Our Ref: WA/25/17/CLP

Application for Certificate of Lawfulness for a Proposed Use or Building

Development Lawful development certificate for the proposed use of first floor of existing garage/outbuilding as a holiday let.

Location Little Box Cottage Walberton Green Arundel

LOCATION & BLOCK PLAN

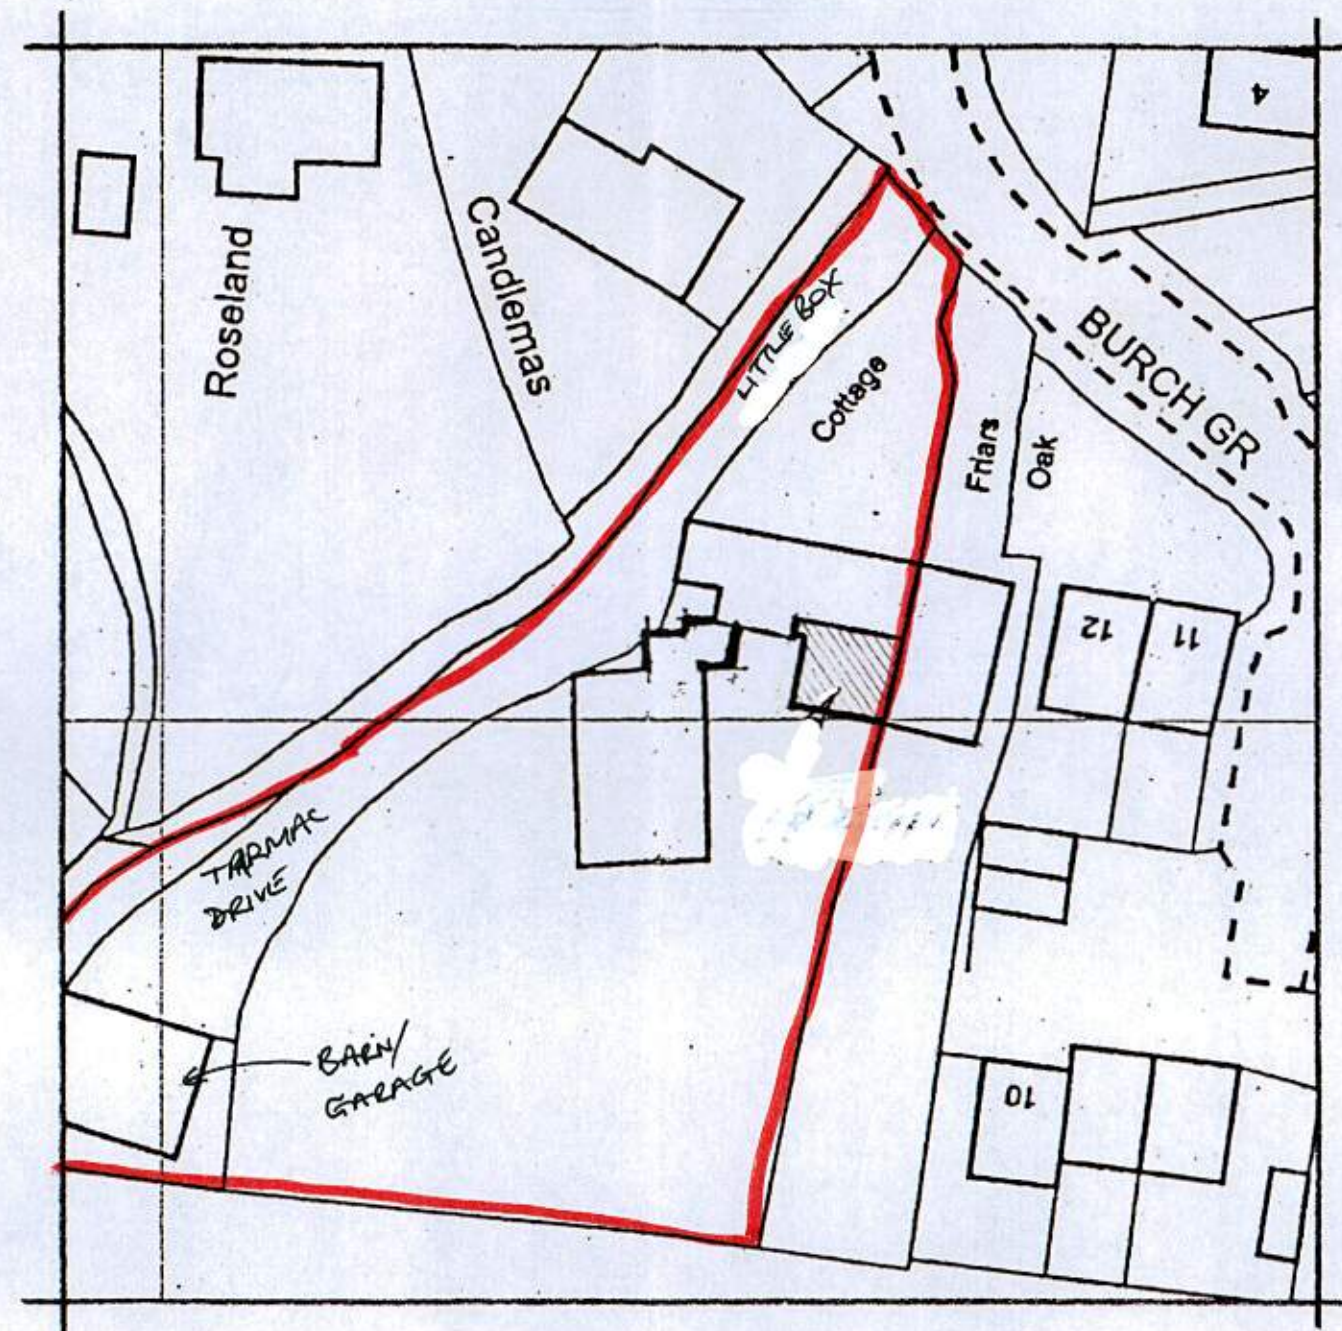
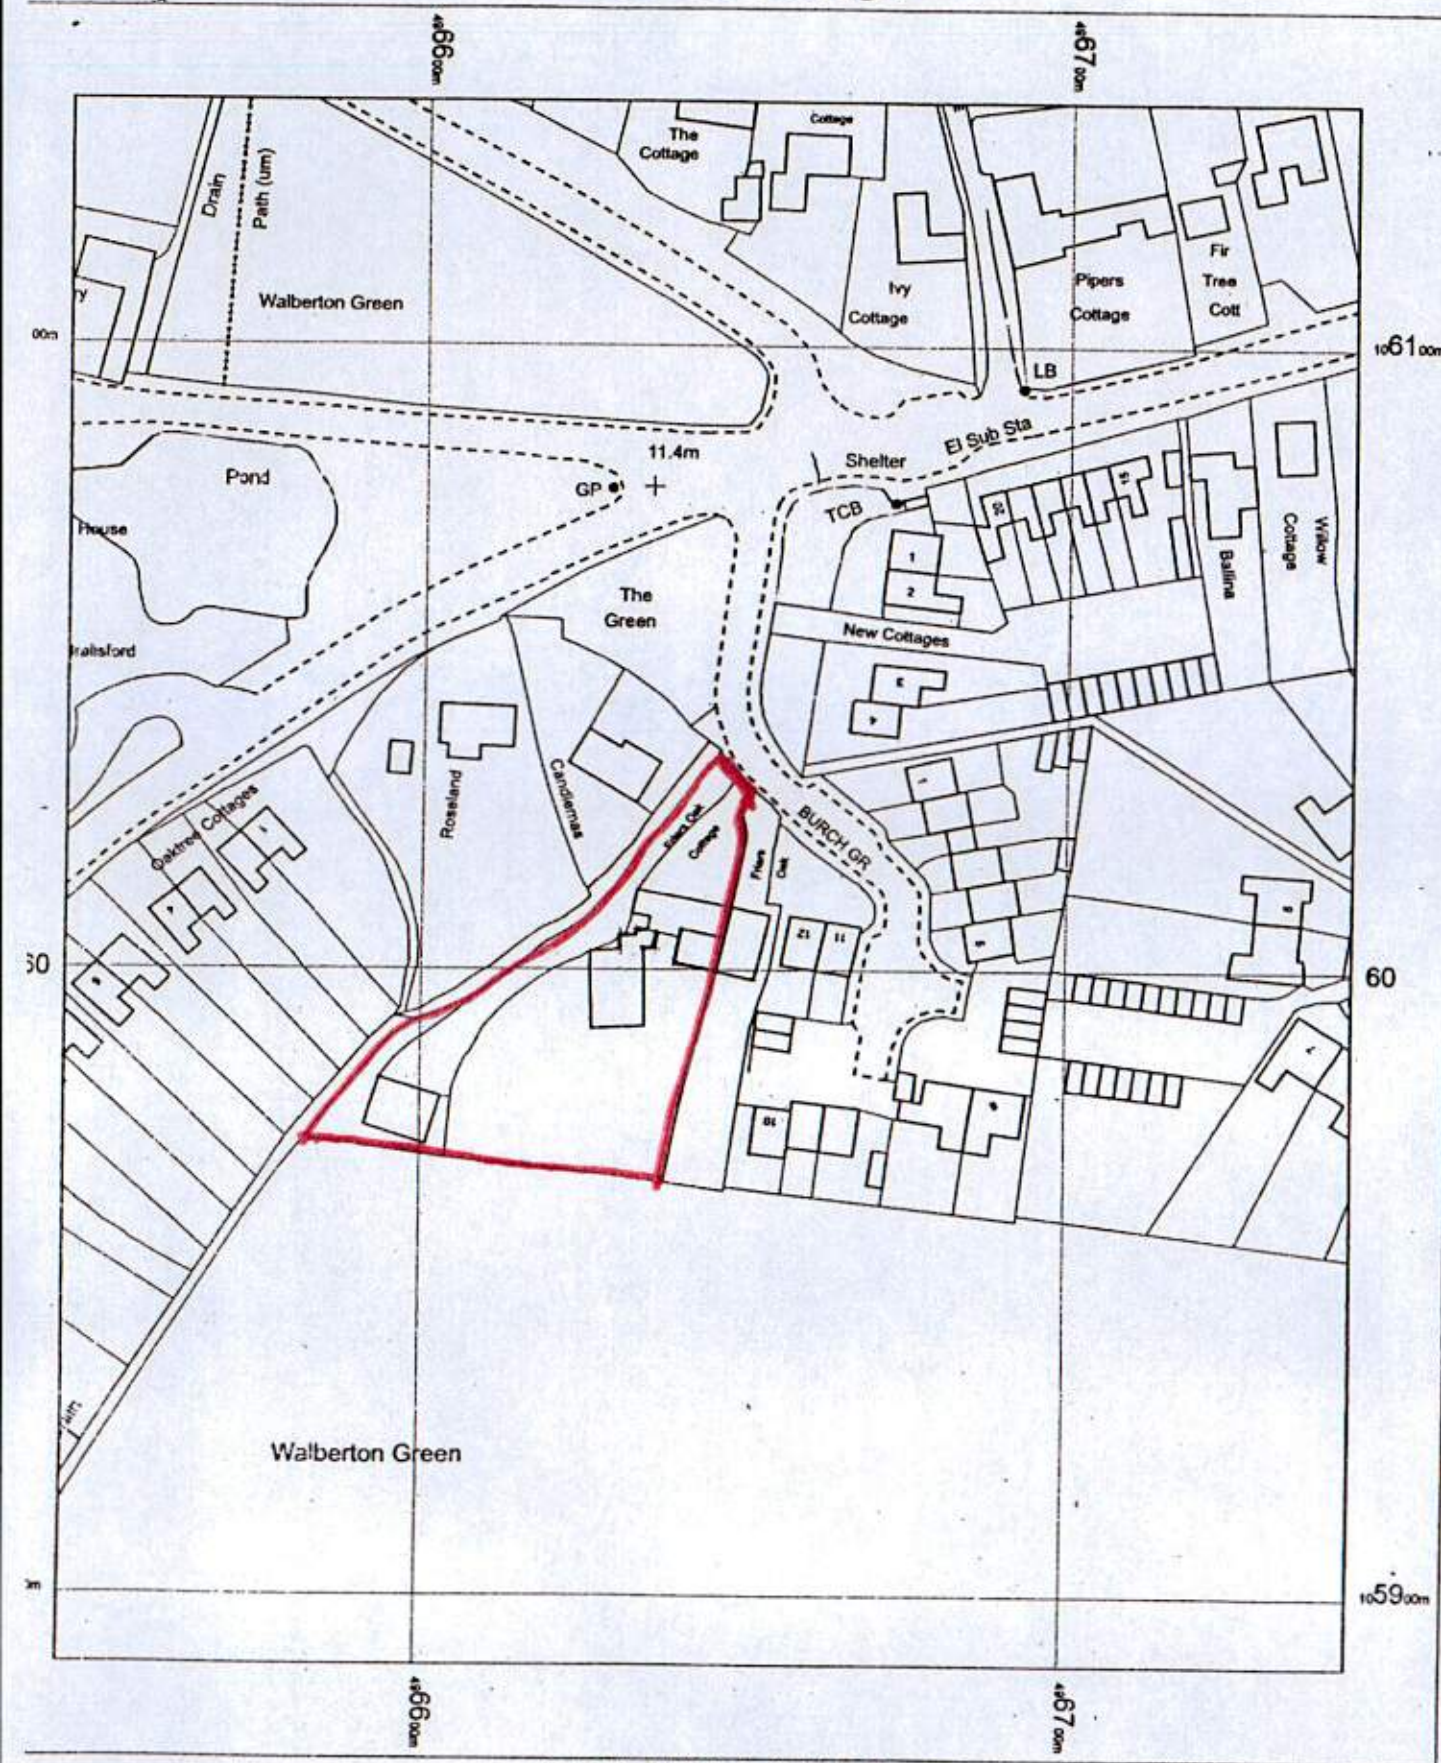
The location and block plan do not scale correctly. Please amend accordingly and return 3 copies to this office. If you scale both plans against each other with a scale ruler, they do not scale the same. If you put a scale ruler on the block plan (1:500) the actual scale bar and the scale ruler do not accord.

FIRST FLOOR PLAN

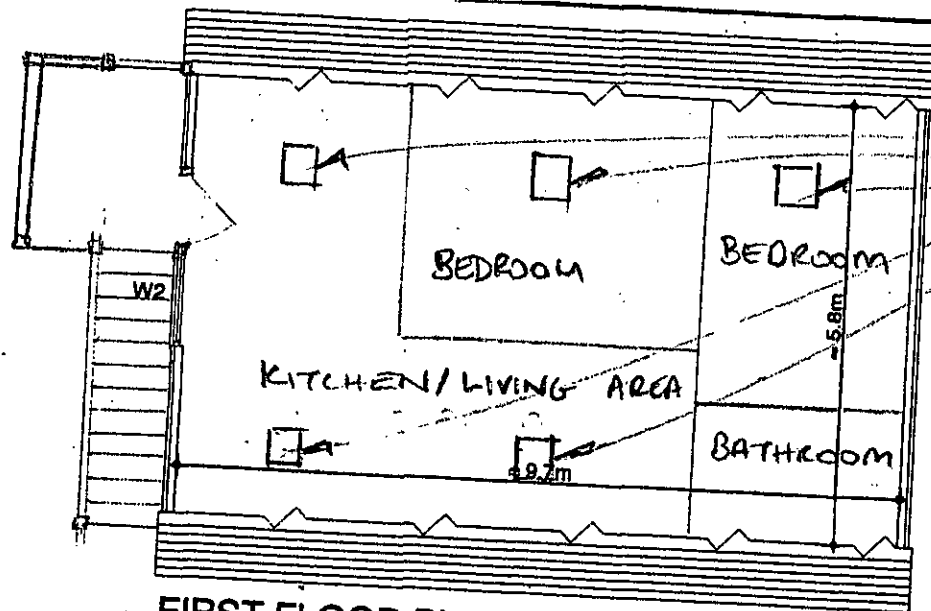
Please show the proposed roof lights on the proposed first floor plan.
